CITY OF ALBUQUERQUE

**Re: Stripes On Lomas
6121 Lomas NE
Traffic Circulation Layout
Architect's Stamp 06-15-2021 (J18-D021A)**

Based upon the information provided in your submittal and field inspection and plan review received, the above referenced plan cannot be approved for Building Permit until the following comments are addressed:

TCL1

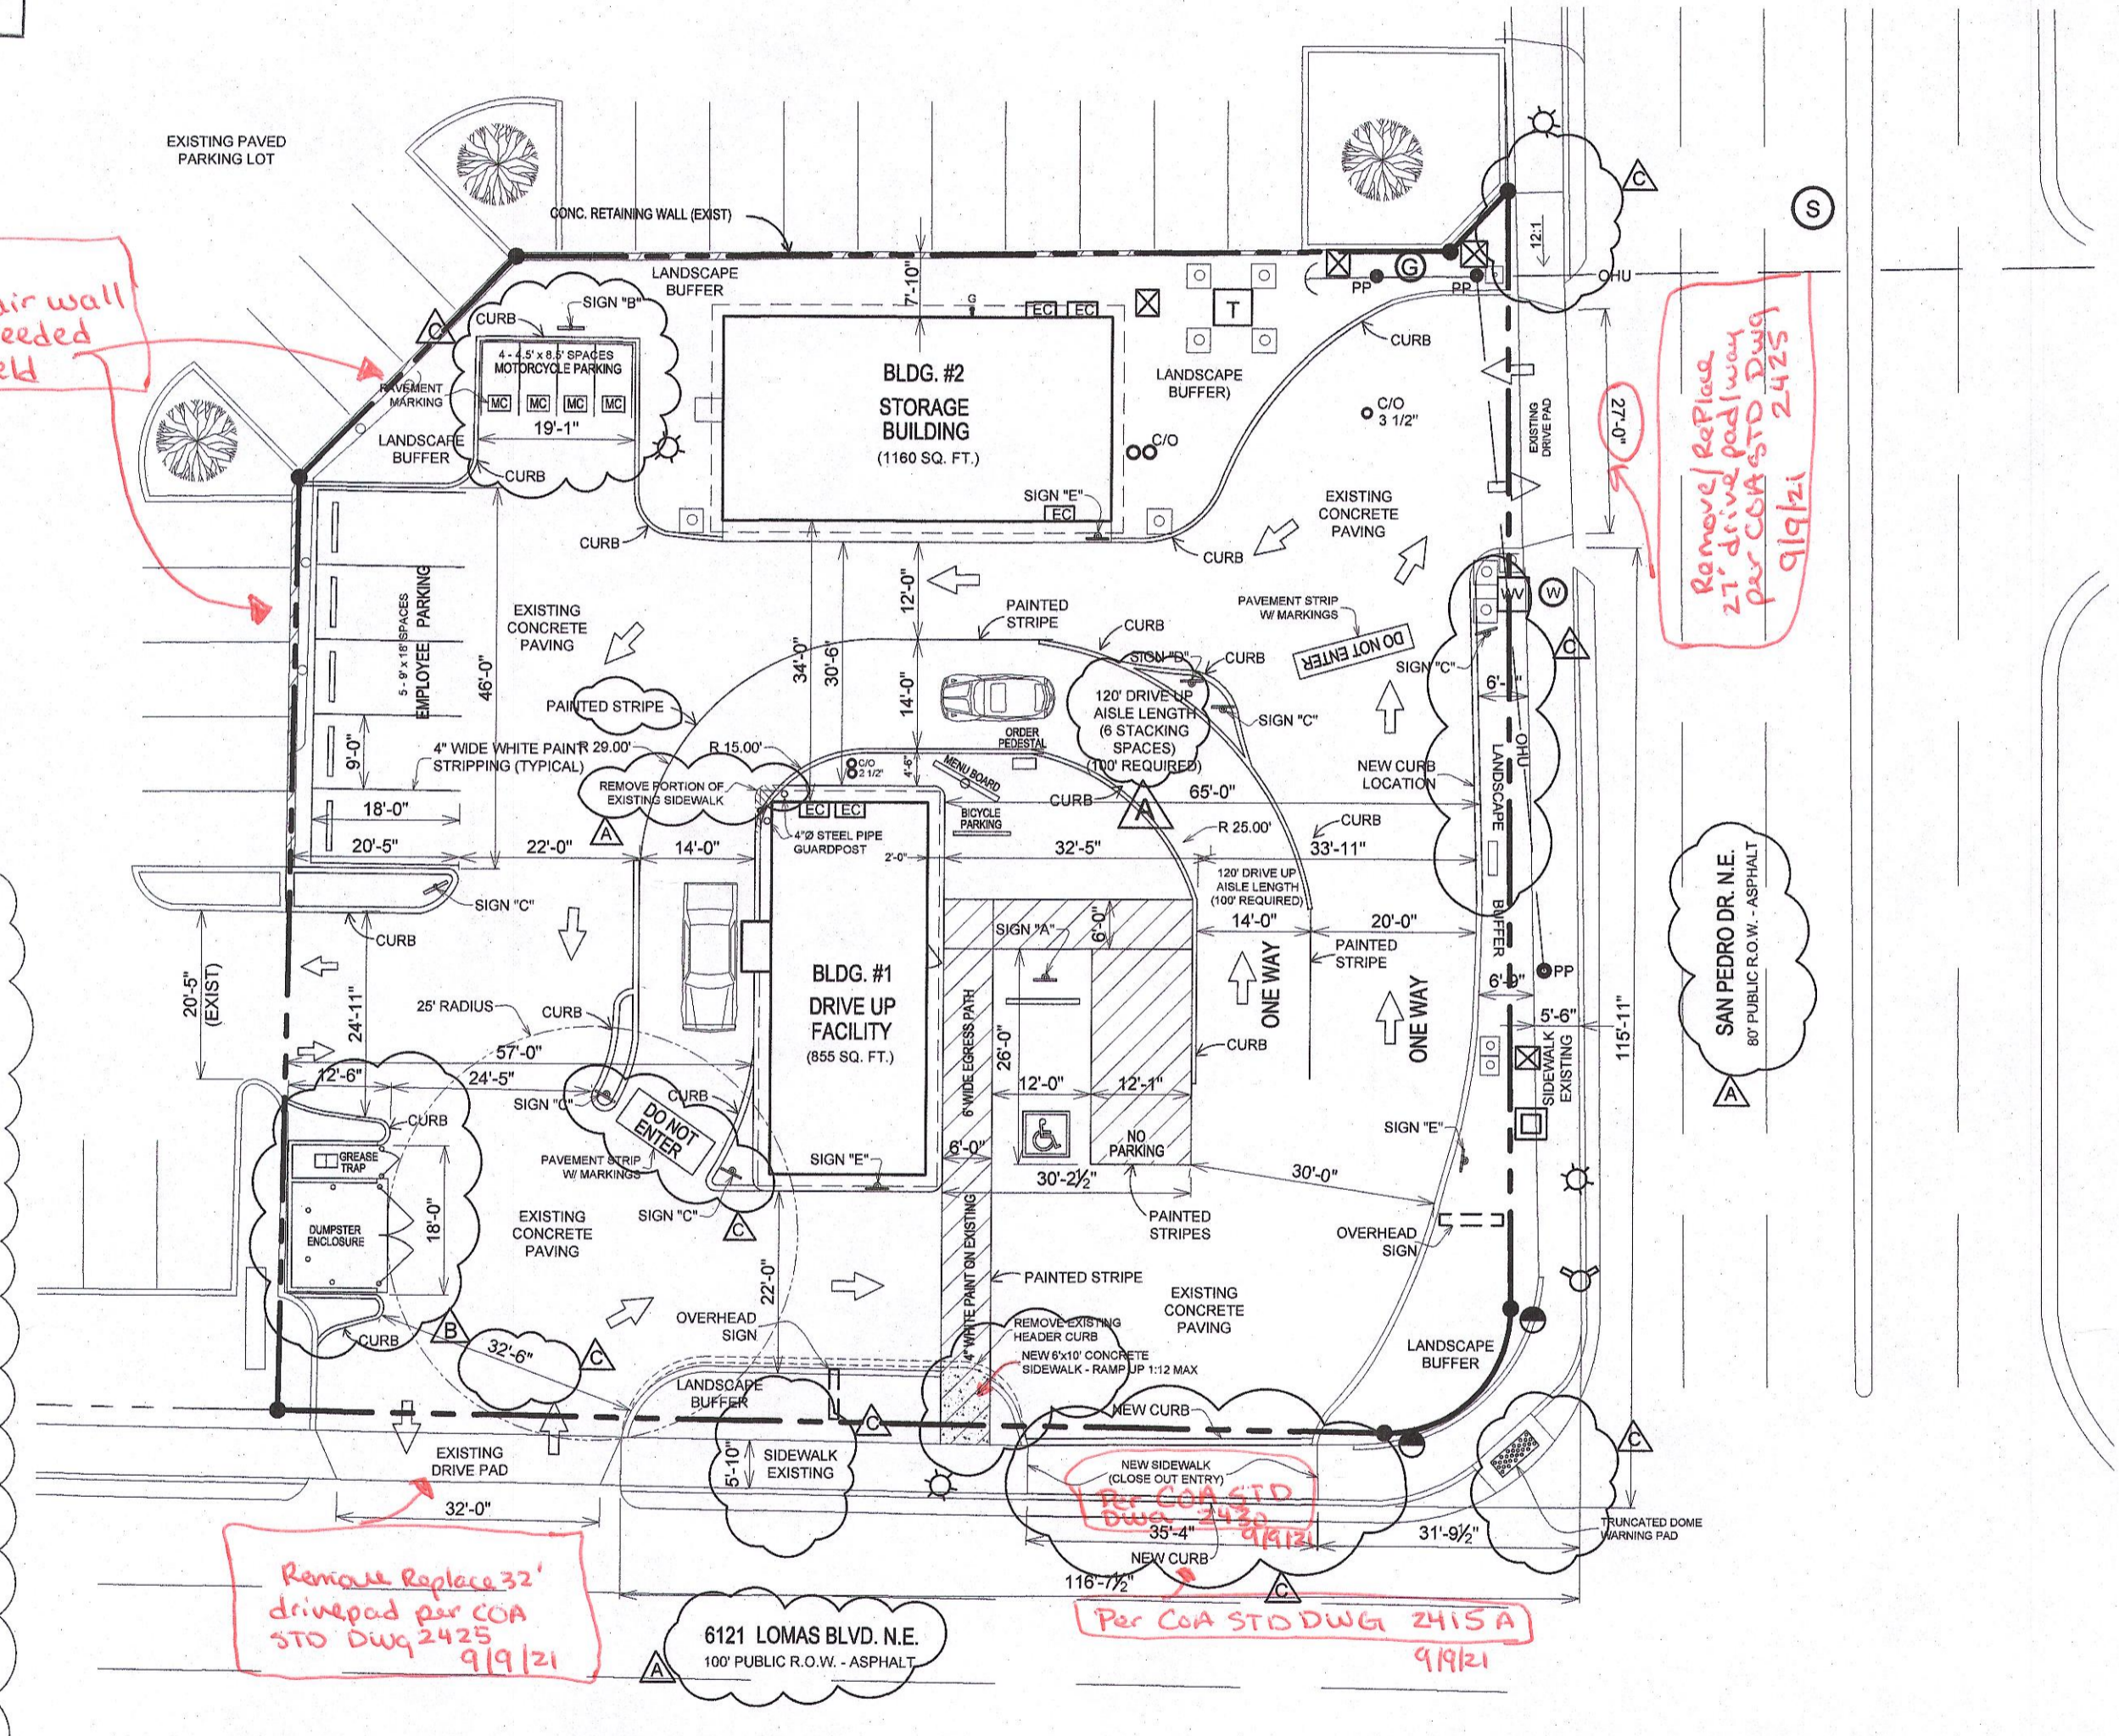
1. All one-way drives shall have "One Way" and "Do Not Enter" signage and pavement markings. **Please show detail and location of posted signs and striping. Provide details of the pavement markings and sign face (All will need to be provided, especially for the one-way orientation).**

1. **FD approval** is needed for proposed site configuration.
2. Existing driveways off San Pedro and Lomas will need to be replace with current/updated drivepad **per COA std dwg 2425, to be ADA compliant.**

3. **All Parking stalls width need to be 8'-6" and not 8'-2".** Please adjust this stall width.
4. **The ADA accessible aisle: The Van aisle should be 8 ft wide.**

6. Curbing is required at drive thru lane departure to shield/protect SIGN C.
7. Motorcycle parking spaces: **Adjacent to proposed stall exists a diagonal retaining wall that will need to be inspected to insure it retaining integrity and stability.**

10. Unused curb cuts must be replaced with sidewalk and curb & gutter. **A build note must be provided referring to the appropriate City Standard drawing (2430 & 2415A) fronting Lomas Blvd drivepad closure segment.**

SHEET
TCL2

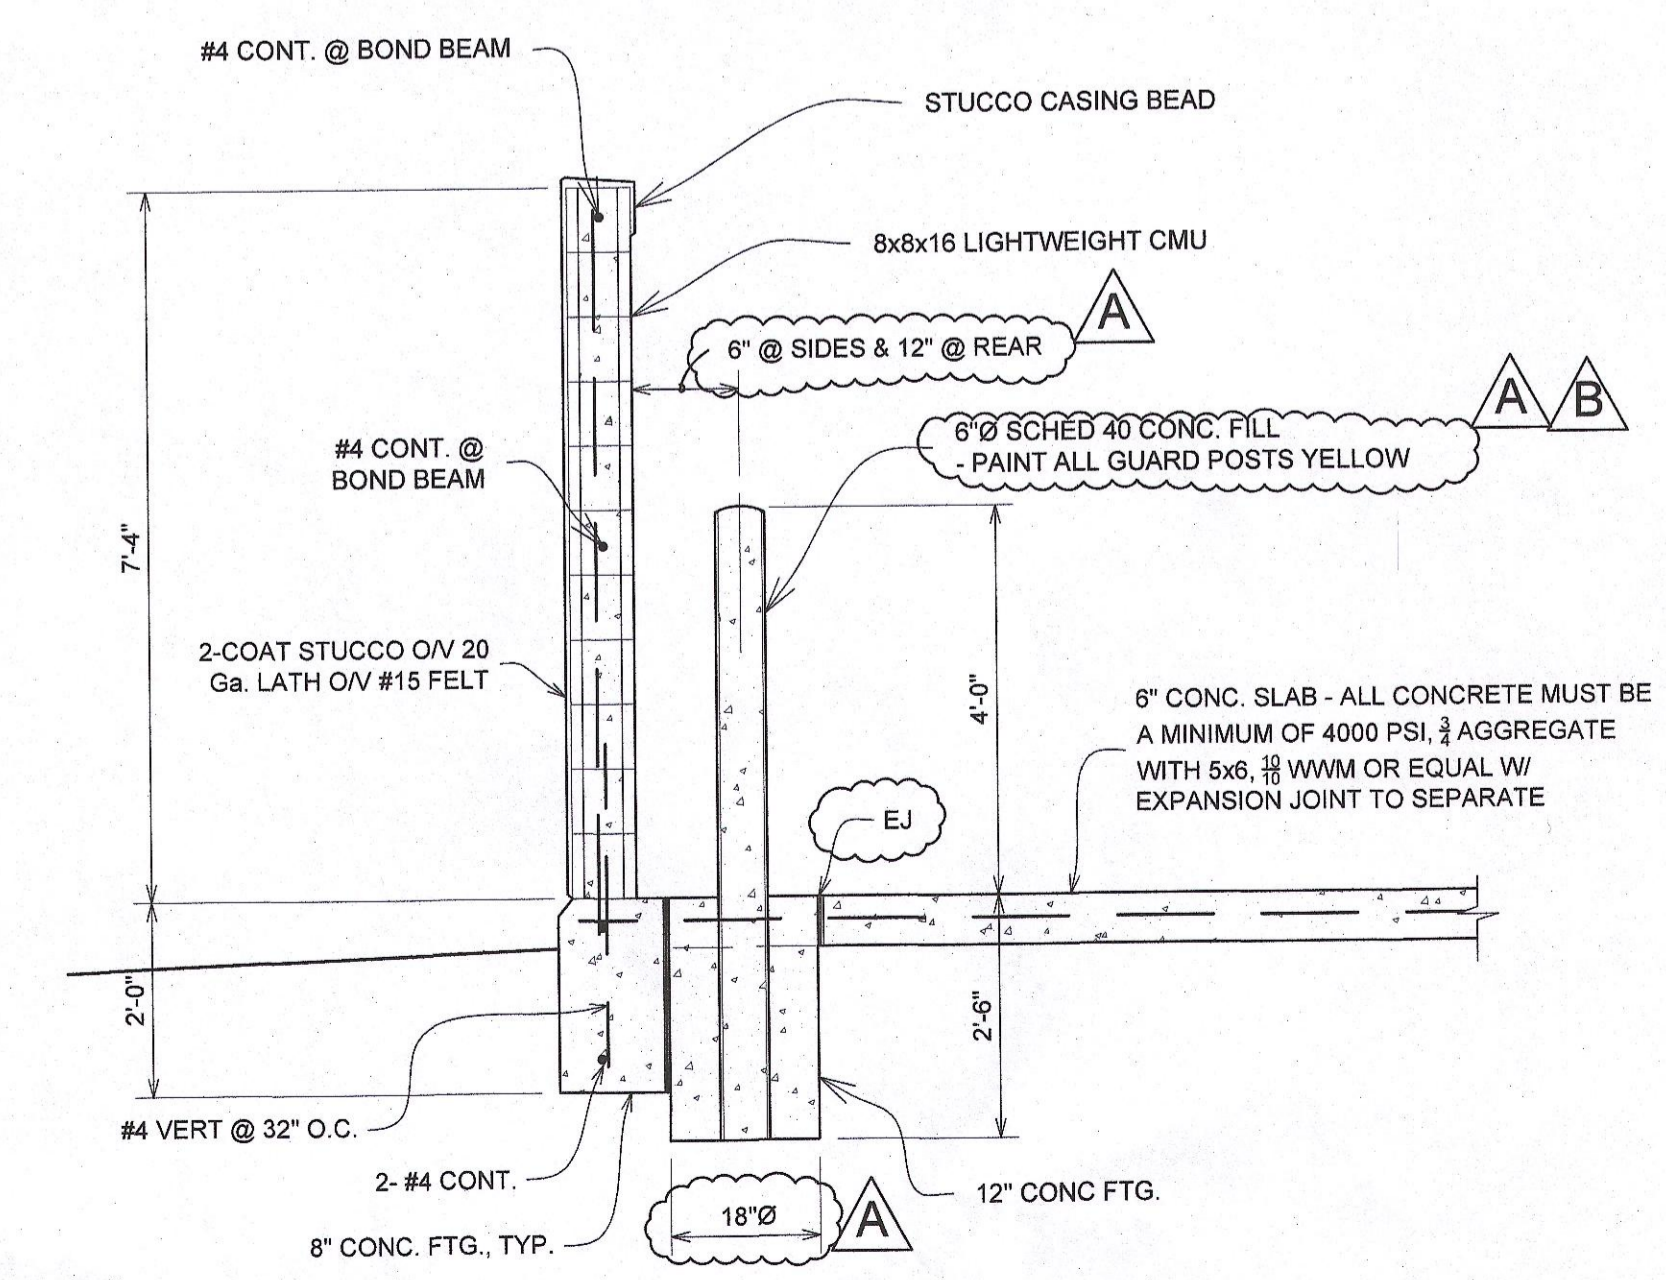
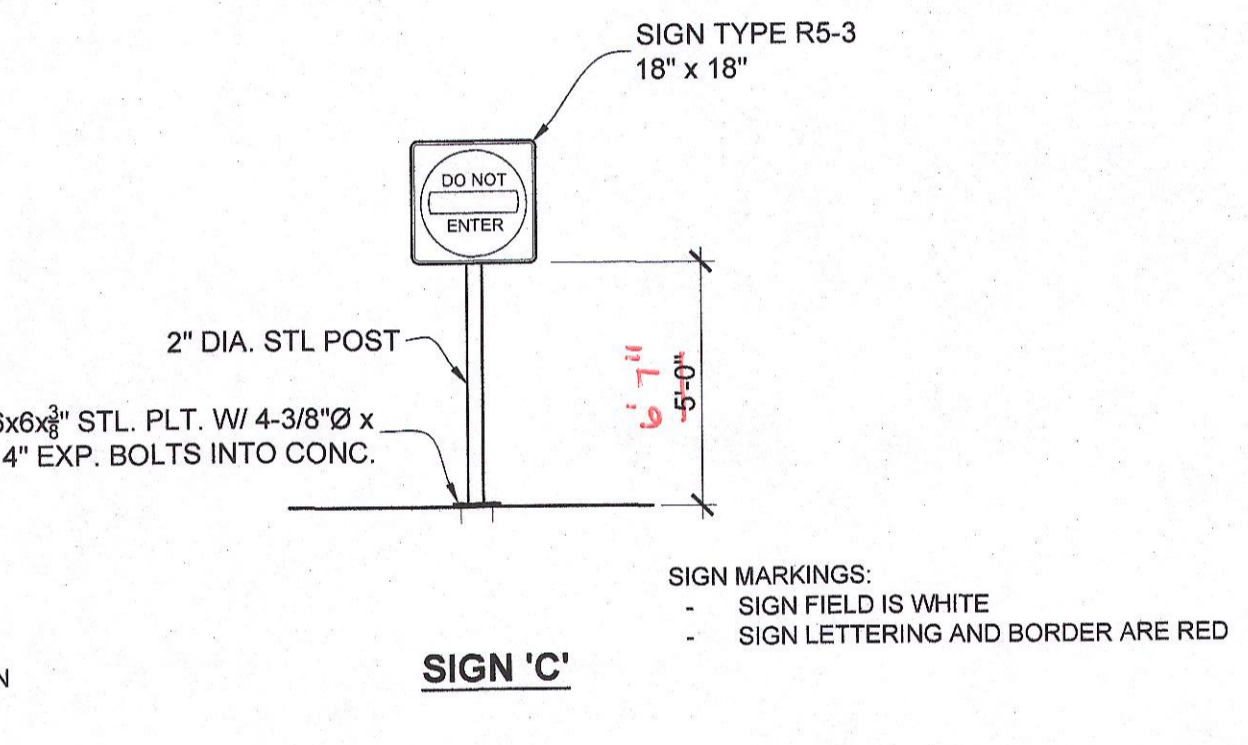
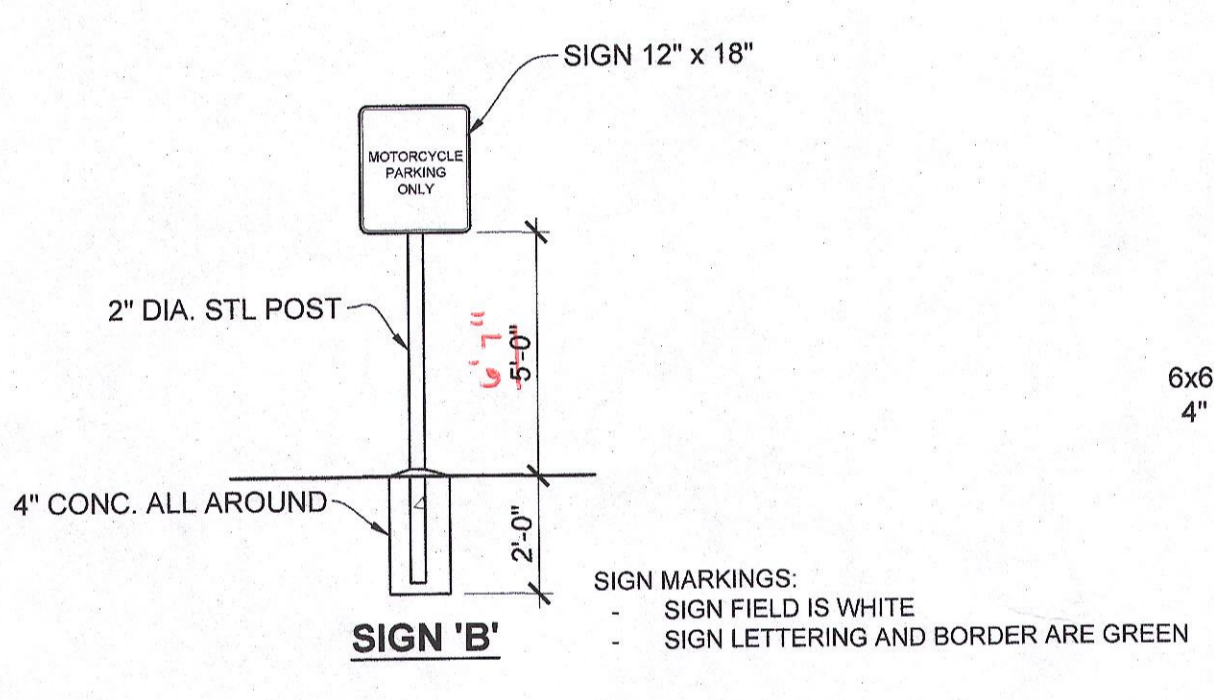
2. **You will need to provide sheet TCL2 (latest to include pavement marking details that have been proposed on site plan).**
3. **All proposed pavement markings detail will need to be provided.**

5. The ADA accessible parking sign must have the required language per 66- 352.4C NMSA 1978 **"Violators Are Subject to a Fine and/or Towing."** Please call out detail and location of signs.
